## Review Response

Project Name: Rosato Pier

Response to: SHL22-014 & SEP22-012 Request for Information, 5652 E Mercer Way (Rosato)

SHEET  
A4.0

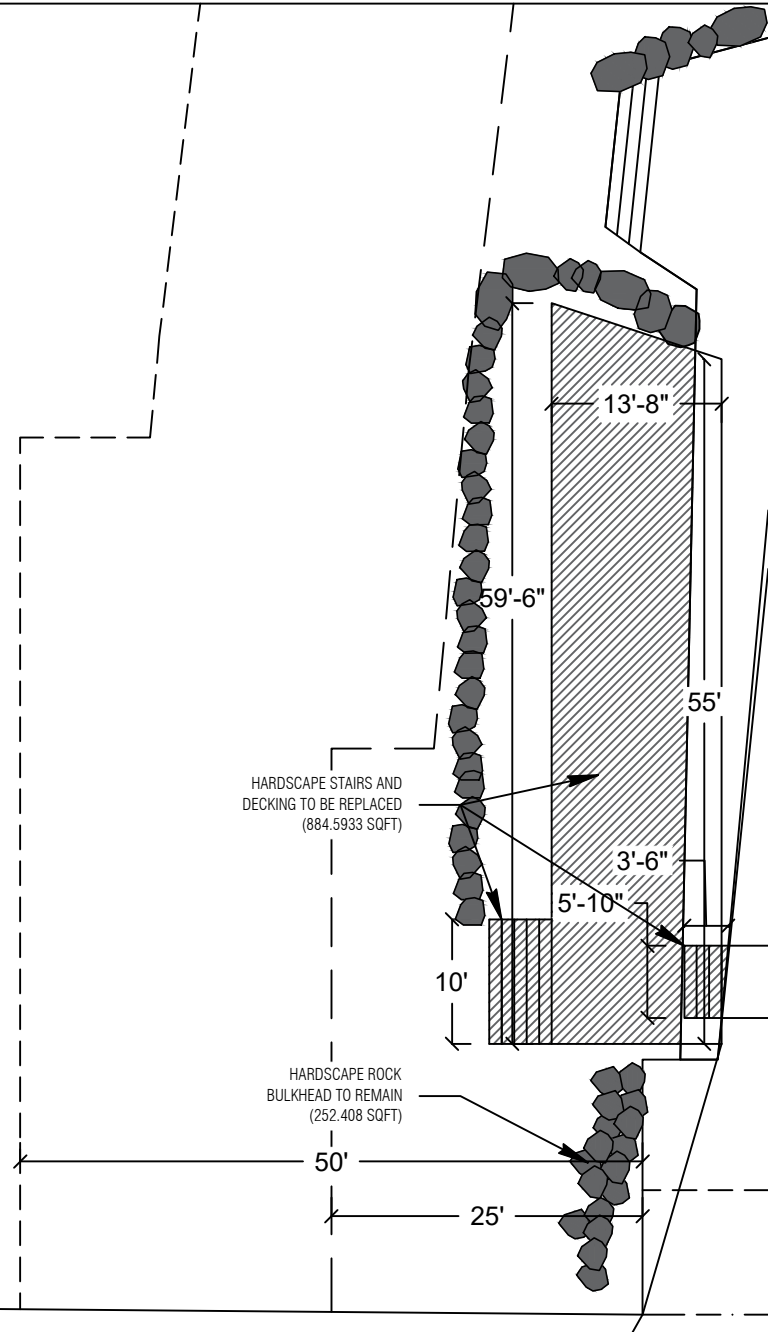
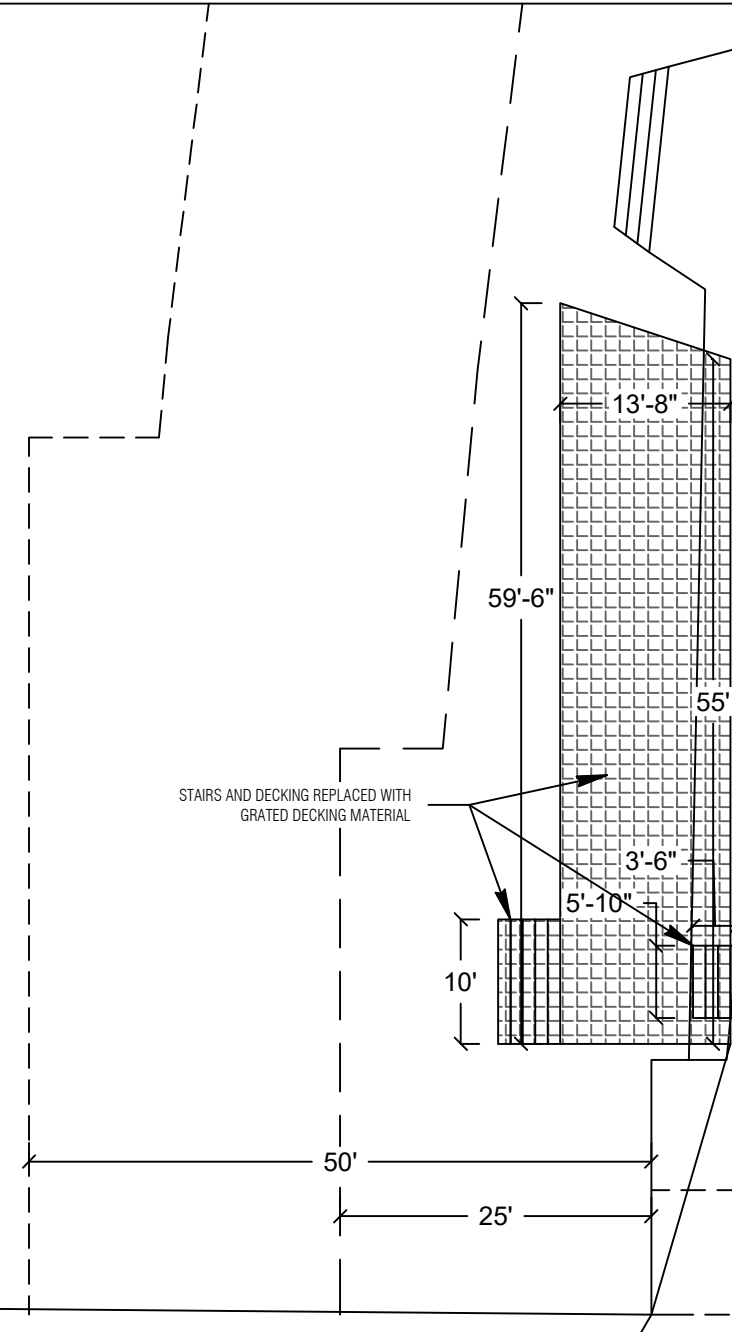
1. The hardscape calculation on sheet A4.0 appears to be incorrect. Replacing the existing deck with grated decking material does not decrease the hardscape for this area. The definition of hardscape found in MICC 19.16 is as follows:

The solid, hard elements or structures that are incorporated into landscaping. The hardscape includes, but is not limited to, structures other than buildings, paved areas other than driving surfaces, stairs, walkways, decks, patios, and similar constructed elements. The hardscape within landscaping is usually made up of materials that include, but are not limited to, wood, stone, concrete, gravel, artificial turf, and permeable pavements or pavers, and similar materials. Hardscape does not include solid, hard elements or structures that are covered by a minimum of two feet of soil intended for softscape (for example, a septic tank or detention tank covered with at least two feet of soil and planted shrubs is not hardscape). Hardscape areas do not include driving surfaces or buildings.

Please revise your hardscape calculations to accurately depict the amount of hardscape proposed within 0-25' from OHWM.

**Please see Sheet A4.0 of updated plan set. Hardscape calculations have been adjusted to not count the grated decking as removal of hardscape. Please also see the submitted site plans from permit #0101-276 (approved in 2001) and #SUB03-006 (approved in 2004), which show the existing overland deck & demonstrate legal non-conformity of hardscape coverage.**

**SHEET  
A11.0**

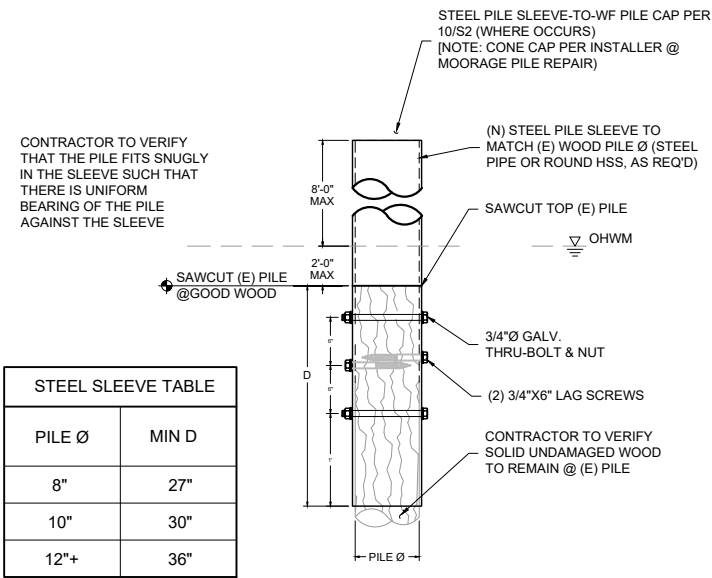
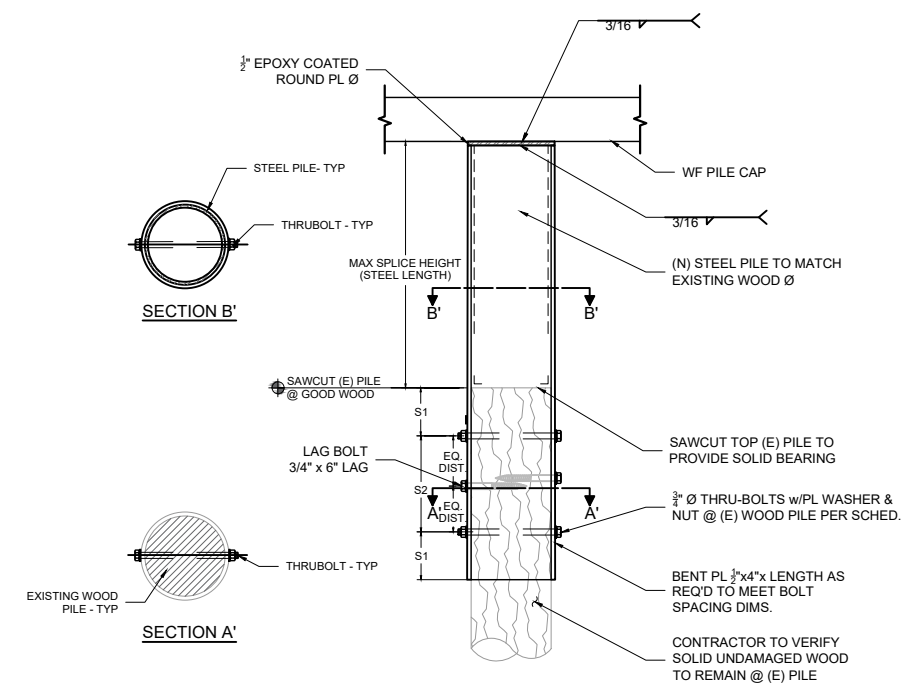
2. You are applying for this permit under MICC 19.13.050(F)(3). It appears that you might be applying for the boatlift under MICC 19.13.050(F)(3) and the repair of the dock and deck under MICC 19.13.050(F)(2). Please show that you meet each of the criteria that you are applying under. If you are applying for the dock repair under the criteria found in MICC 19.13.050(F)(3), this project does not meet the criteria in section (ii) in that section. The width of the dock is too wide, and you will need to revise the width to comply with Table D.

**Please evaluate project under MICC 19.13.050(F)(2). Sheet A11 has been updated to reflect this. The relocation of the boat lift should also fit under this section, as (F)(2)iv stipulates that a structure may be relocated if it results in a net gain of**

**ecological function & greater code conformity. The original permitted location of the lift was within 30' of the OHWM – the new location at the end of the dock improves the nearshore habitat conditions & allows the lift to be in the deepest possible water depths, as noted in the NNL report.**
